**26 Moody St - permit #2017-01260**

I have completed my initial zoning review for the permit to change the use of the building to a single family home. I have a few questions before I can sign off for zoning. It has been a little confusing because you have already been issued two fast track permits. It is a little hard to tell where the work approved under permit 2017-01281 ends and the work on this permit begins.

1 Proposed First Floor Plan

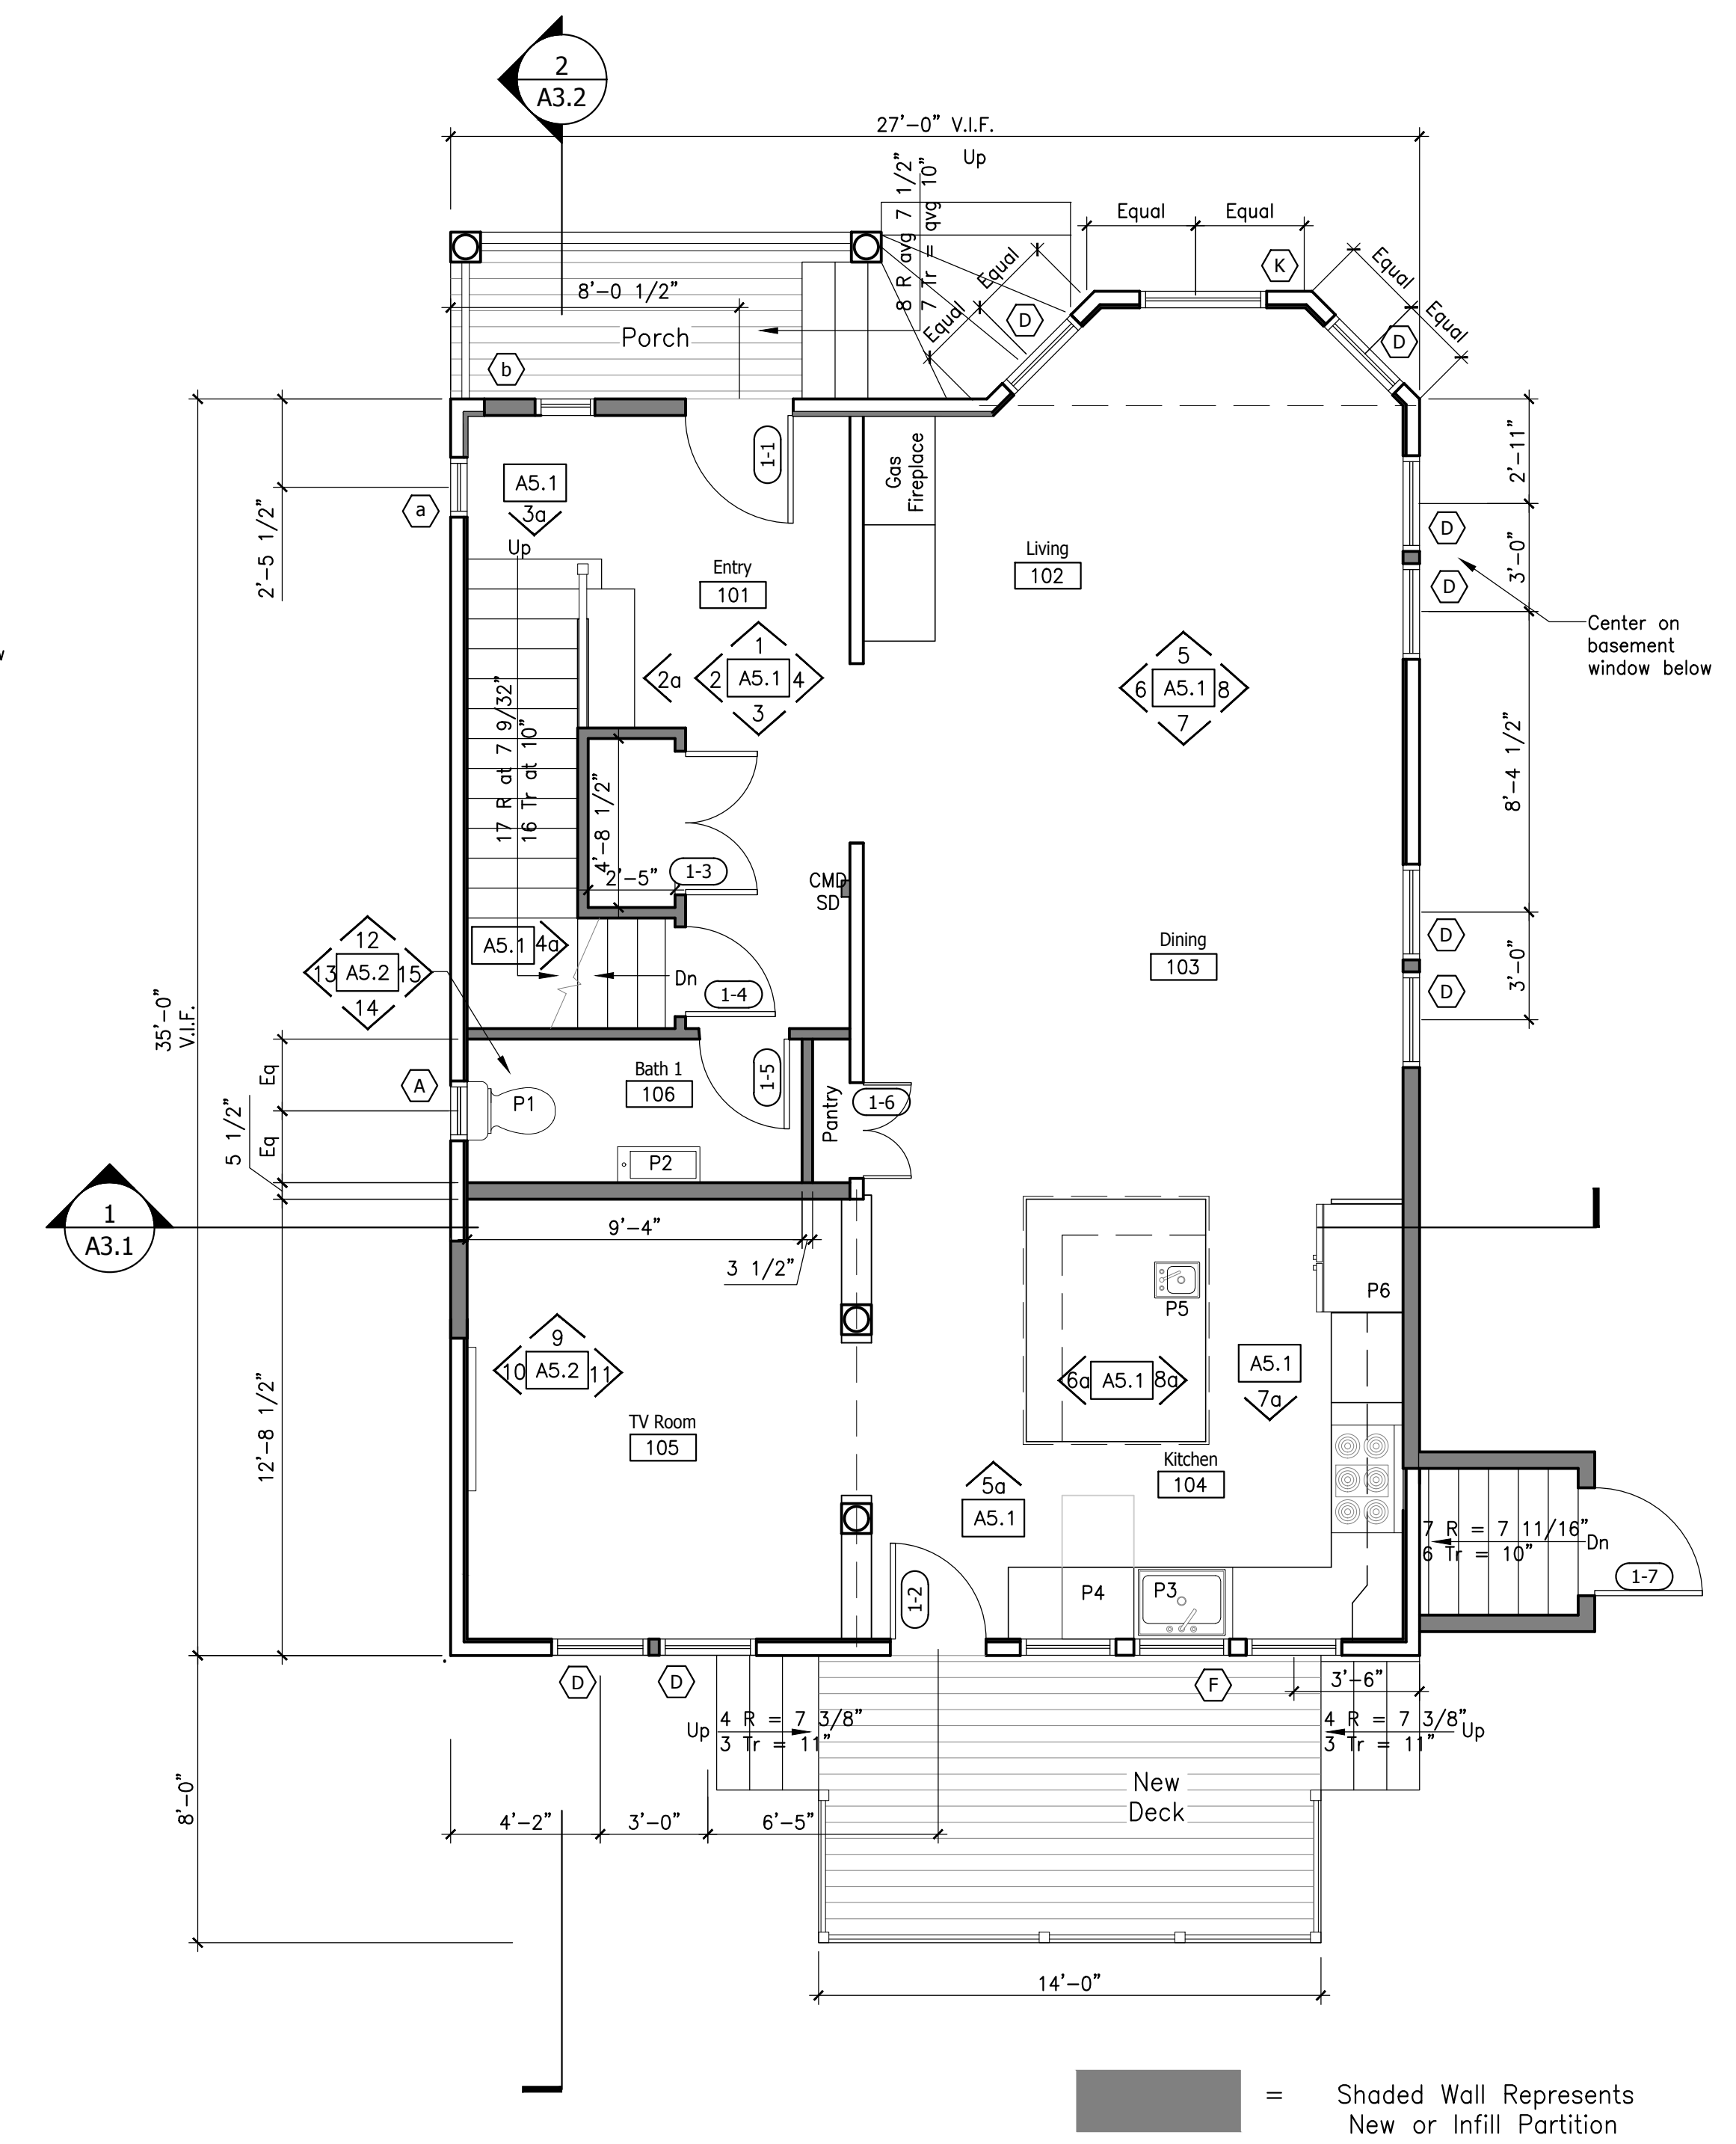
2. Is the attic going to be occupied or finished at this time?
3. I need some clarification about the new first floor deck. From plan A2.3 (South Elevation) and Plan A1.1 (First and Second floor Plan) the deck is 14' x 8' with a set of steps going off each side of it. The outline of the new deck on the proposed site plan is unclear. The gray area appears to show it but the gray area goes beyond the proposed stairs and it does not show the stairs on the other side going towards the right side property line.

- 1.) Yes to all - adding the deck over the front porch, the doghouse, and the rear deck, as well as moving windows and interior design.
- 2.) No, the attic will not be occupied, just roughed in for a future bedroom or other use.
- 3.) I believe the site plan does show both sets of deck stairs. You are correct there are a few areas of shaded gray that are somewhat confusing. I can swing by tomorrow if that would be helpful?
- 4.) The curb cut is complete. The permit for that was pulled by Ruck Paving. I believe I have a copy of that if you need it.
